Fordham (Cambs) Walking Group

Planning Inspectorate Reference EN010106 Sunnica Energy Farm

Rebuttal of Sunnica Project Team Document

**Issues paper: Public Rights of Way Experience Note
submitted at Deadline 6**

Drawing Title  
**FIGURE 10-14C  
 LANDSCAPE MASTERPLAN  
 SUNNICA EAST SITE B**

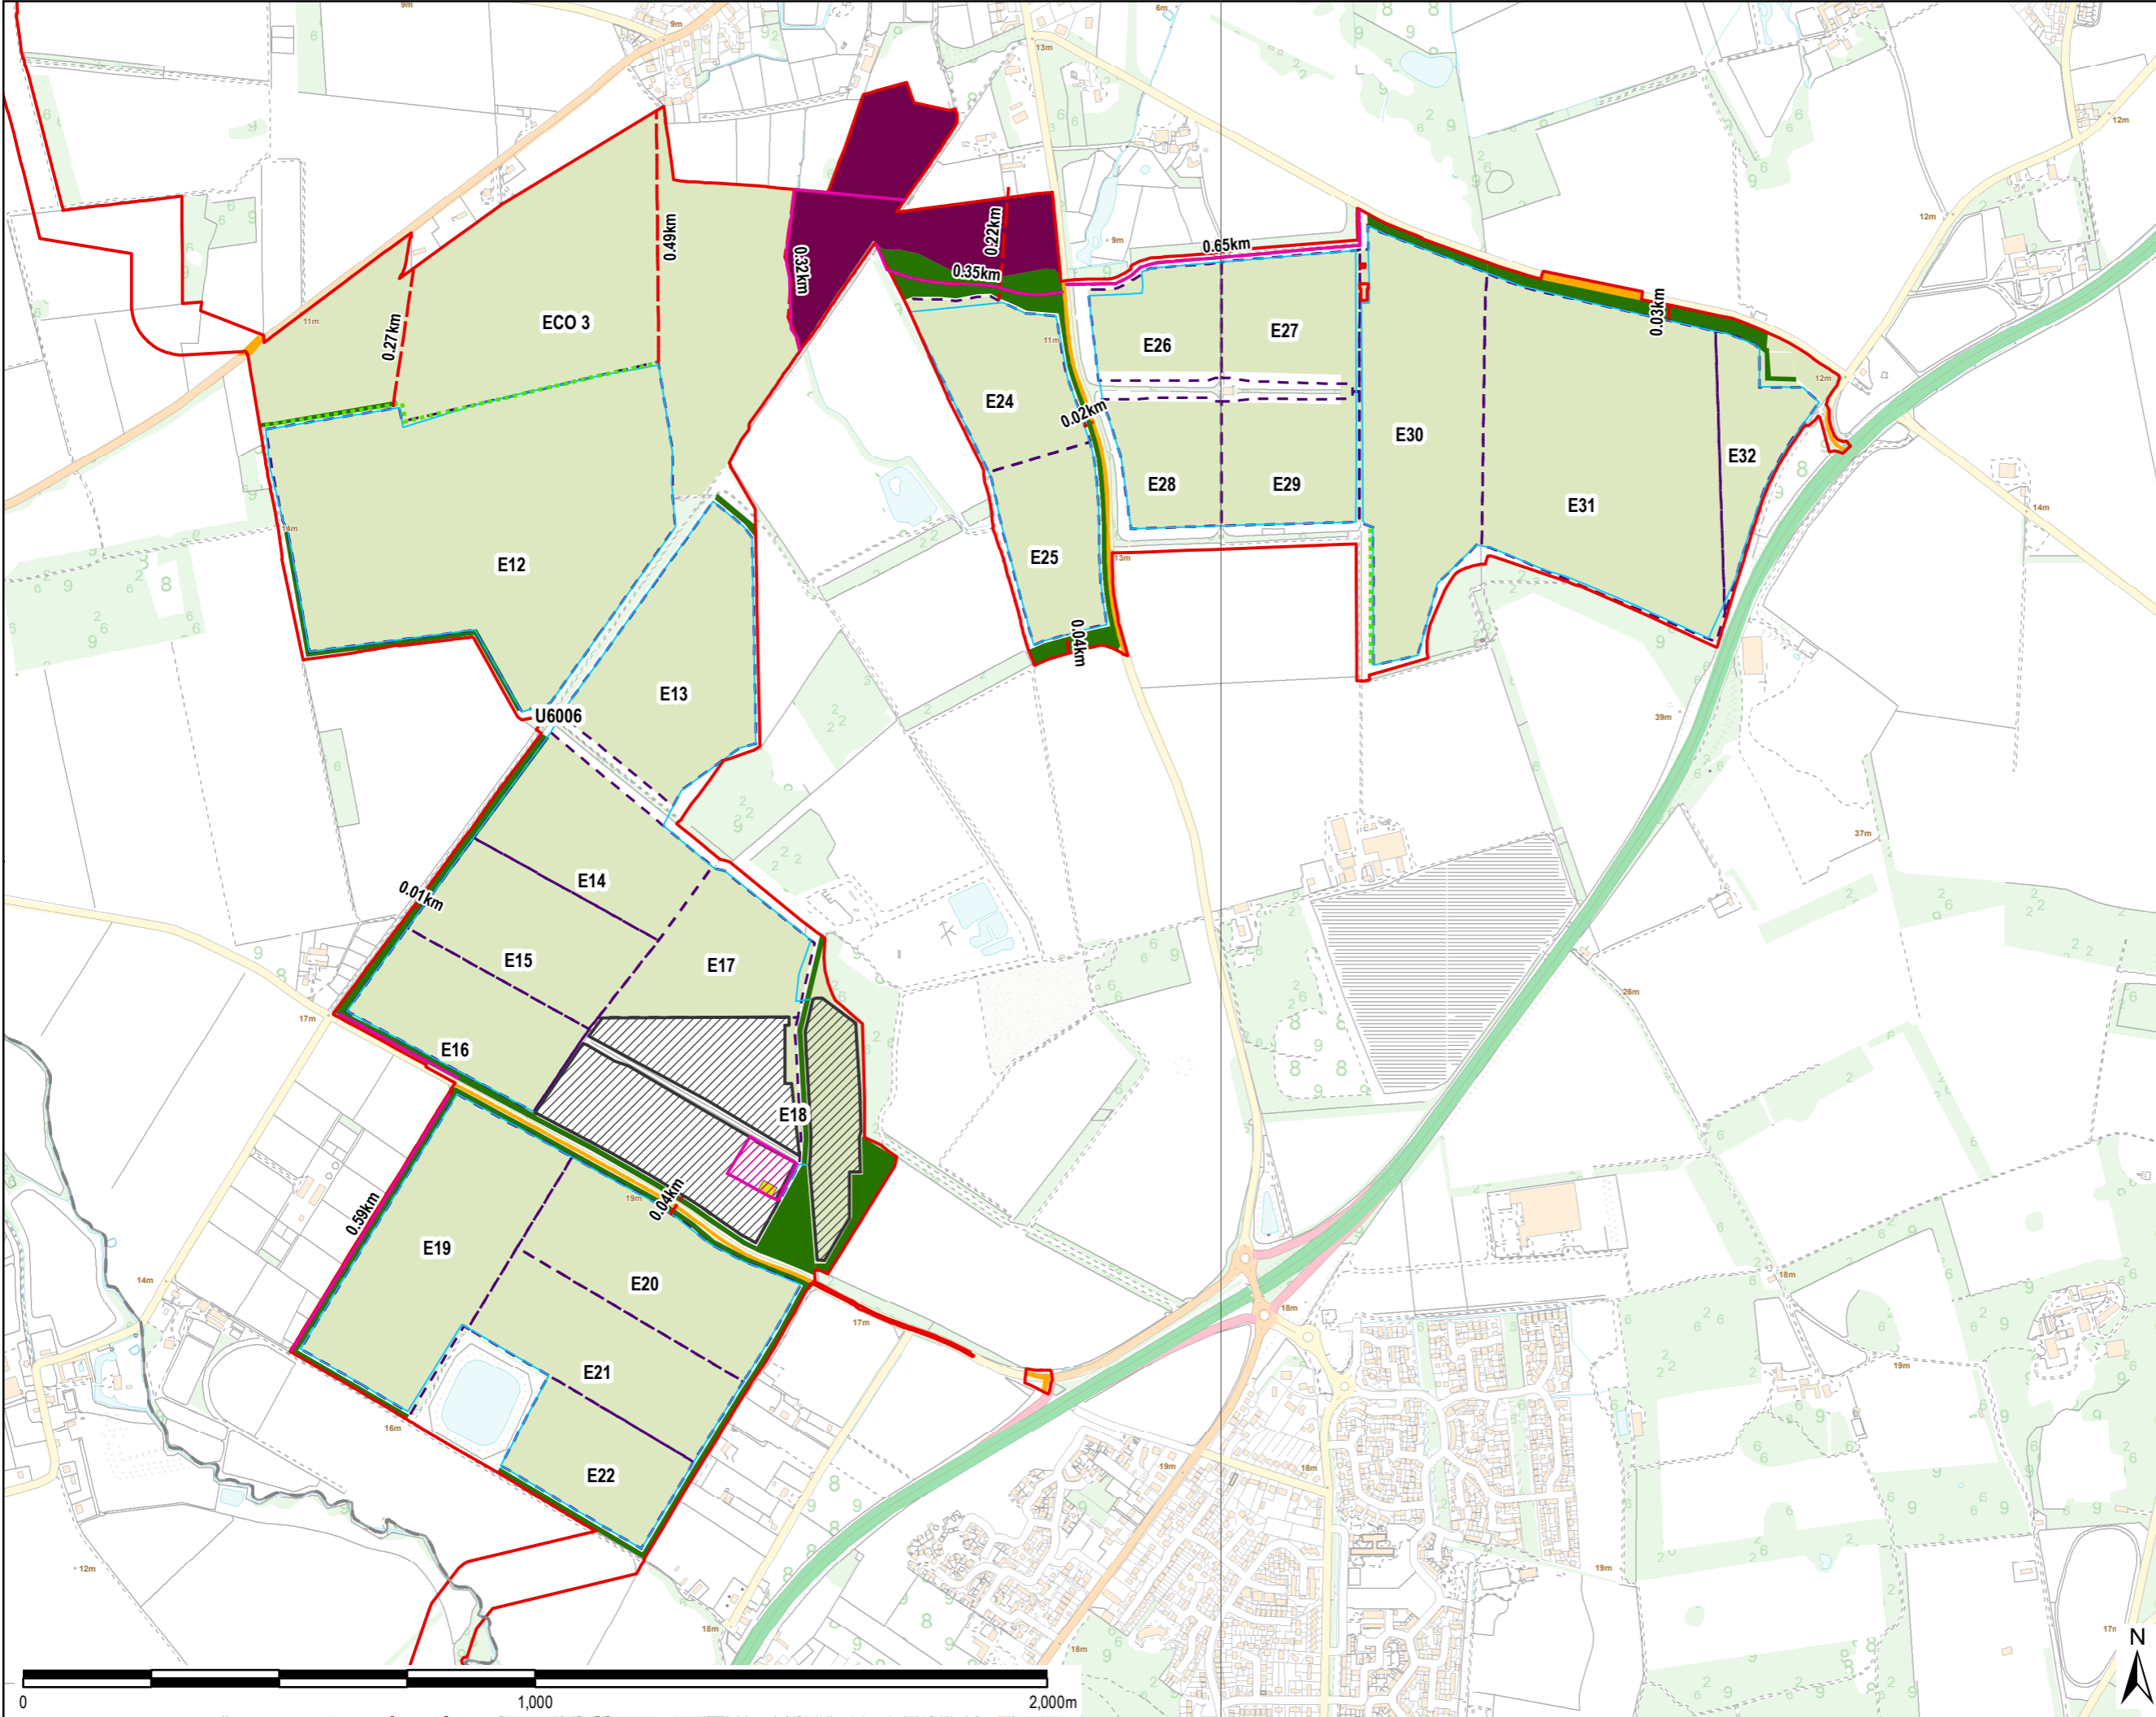
2.5 *“4.1.25 Badlingham Road U6006 is an unclassified road marked on Ordnance Survey maps as an “other route with public access”. U6006 extends 2.3km north from Elms Road to Worlington, across the eastern part of Sunnica East Site B. U6006 forms part of the route linking Worlington to Badlingham. South of Elms Road the U6006 joins footpath W-257/010/0 to Badlingham”.*

This is incorrect, the point south of Elms Road where the U6006 joins footpath W-257/010/0 goes to Chippenham.

2.6 *“4.1.29 U6006 passes through the centre of Sunnica East Site B and is enclosed by dense vegetation, with a high proportion of evergreen trees and scrub on both sides through the section where solar panels are proposed within parcels E12 and E13, restricting views out to the surrounding landscape. It is technically a road, but it is narrow and unsurfaced and is predominantly used for recreation”.*

This is in part incorrect; the part of Badlingham Road south of Elms Road is metalled. To say now that it is predominantly used for recreation contradicts the applicant’s stance in their response to FCWG’s deadline 3 written statement. Sunnica claimed that Badlingham Road is hazardous, in responding to this group’s suggestion that their parallel route through E19 is hardly needed, and relatively low on the list of priorities for better routes across the wide area of the DCO. FCWG regard Badlingham Road, with its minimal vehicular traffic and generous verges, a safe and pleasant walking route. Also, the Sunnica route along the edge of a large field of solar panels is markedly less attractive. With that in mind, a more effective investment could be made in permissive routes elsewhere across the expanse of the DCO site.

2.7 *“4.1.35 Over 1.5km of new permissive routes are proposed at the northern end of U6006, creating a new link to Golf Links Road to the north-east and providing a new, more direct link to Worlington to the north. The permissive route would go through proposed woodland planting north of E24, continuing along the north of parcels E26 and E27, set within a grassland buffer and alongside the existing woodland to the north. An additional permissive route is proposed to the north-west of U6006 crossing through the proposed ecological grassland south of Joan’s Meadow. This will create a short, circular route through attractive, biodiverse acid grassland close to the edge of the village, utilising an existing track”.*

The existing route from the point on Green Lane U6006 52°19.797'N, 0°29.042'E, to 52°19.791'N, 0°29.843'E on Golf Links Road is 0.72 mile. The 'possible' permissive route proposed by the applicant between these points is longer at 0.74 mile and passes alongside solar panels. Given the circumstances, this proposed permissive route does not improve connectivity.

It simply does not provide a "*more direct link to Worlington to the north*".

2.8 "4.1.47 New permissive routes are proposed adjacent to Elms Road south of E16 and west of E19. These routes will provide valuable, off road connections between existing routes from Red Lodge and Badlingham with U6006, as shown on the Environmental Masterplan [REP5-011]. There would be views west across the paddocks of Brookside Stud and the rural landscape beyond."

The existing NMU route from point 52°18.985'N, 0°28.032'E on Elms Road to Badlingham point 52°18.688'N, 0°27.712'E is just 0.40 mile. It passes along a very quiet pleasant lane as indicated at paragraph 2.6.

The Applicant's possible permissive route between these two points is 0.75 mile and passes alongside solar panels. It very hard to see how this longer route would be enticing to NMUs, nor would it add anything whatsoever to connectivity.

The applicant's claimed benefit of *valuable, off road connections* is simply not true.

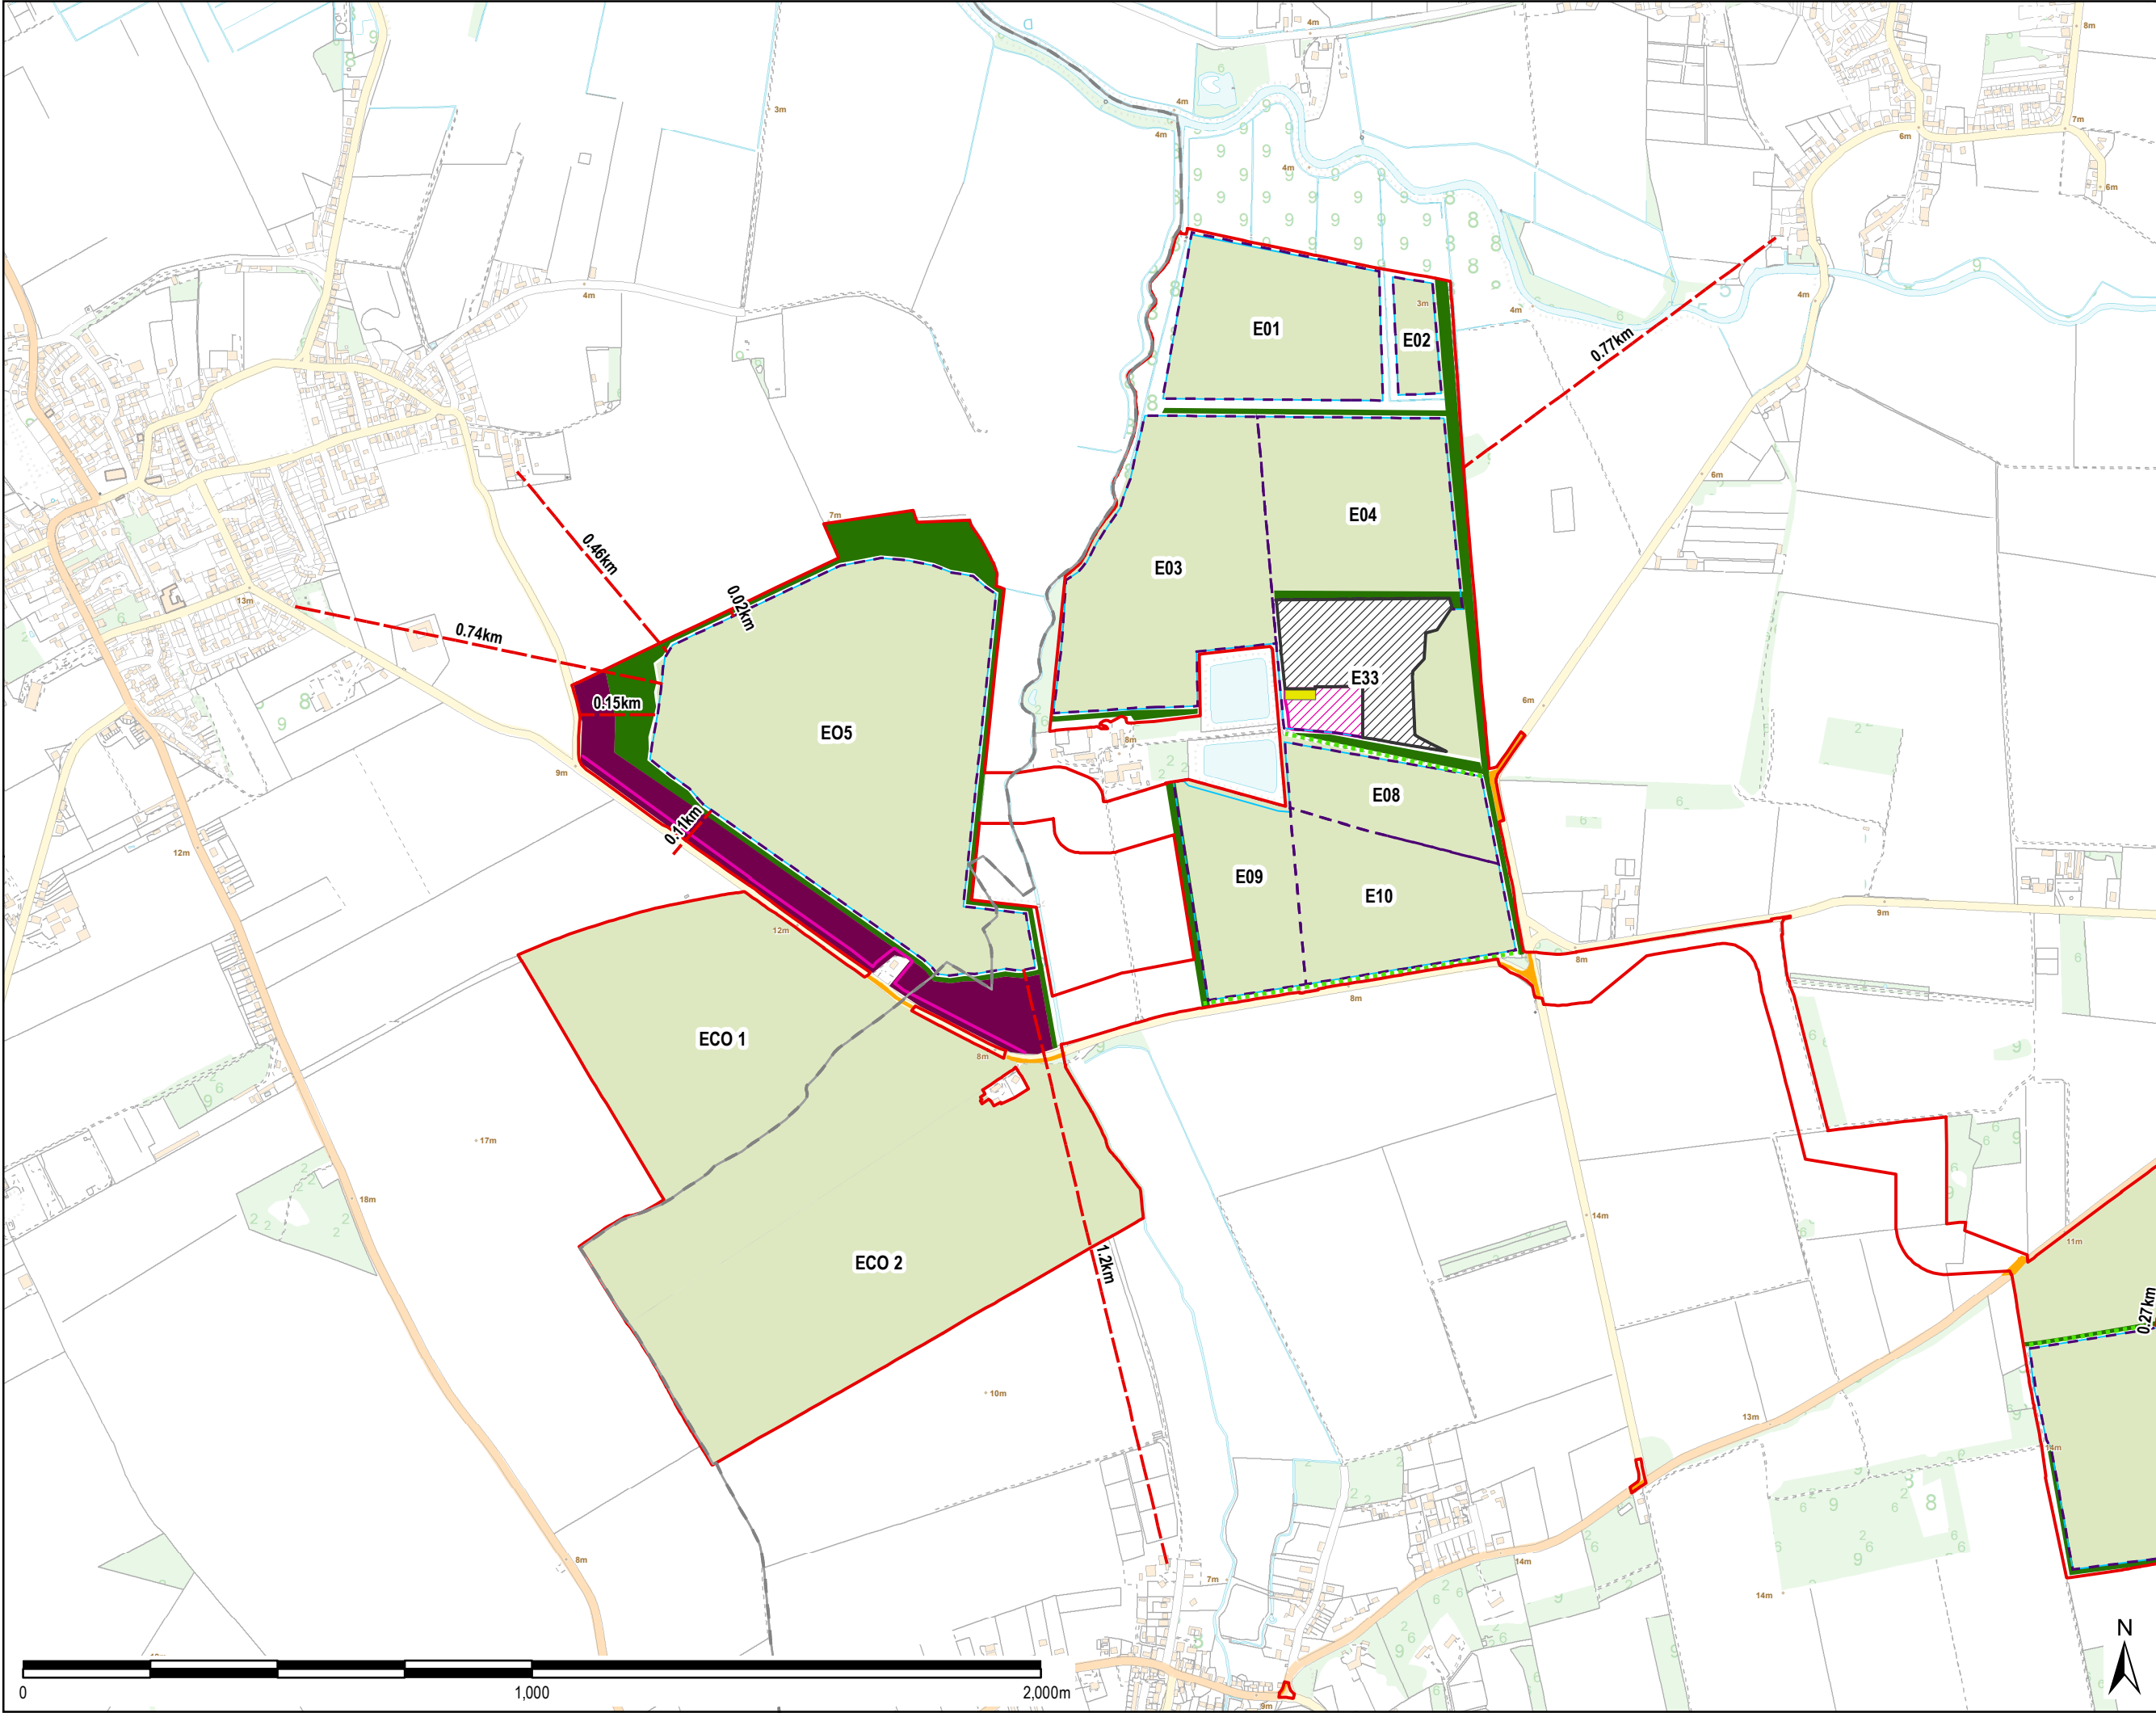
2.4 *“4.1.14 The Scheme will provide a new permissive path which will complete the link between Freckenham and Isleham, via a route through the grassland proposed to the south of parcel E05, parallel with Beck Road, thereby creating an improved, safer situation than is currently the case”.*

This is incorrect as there will still be a missing link as no details have been submitted to avoid walking along Sheldrick’s Road.
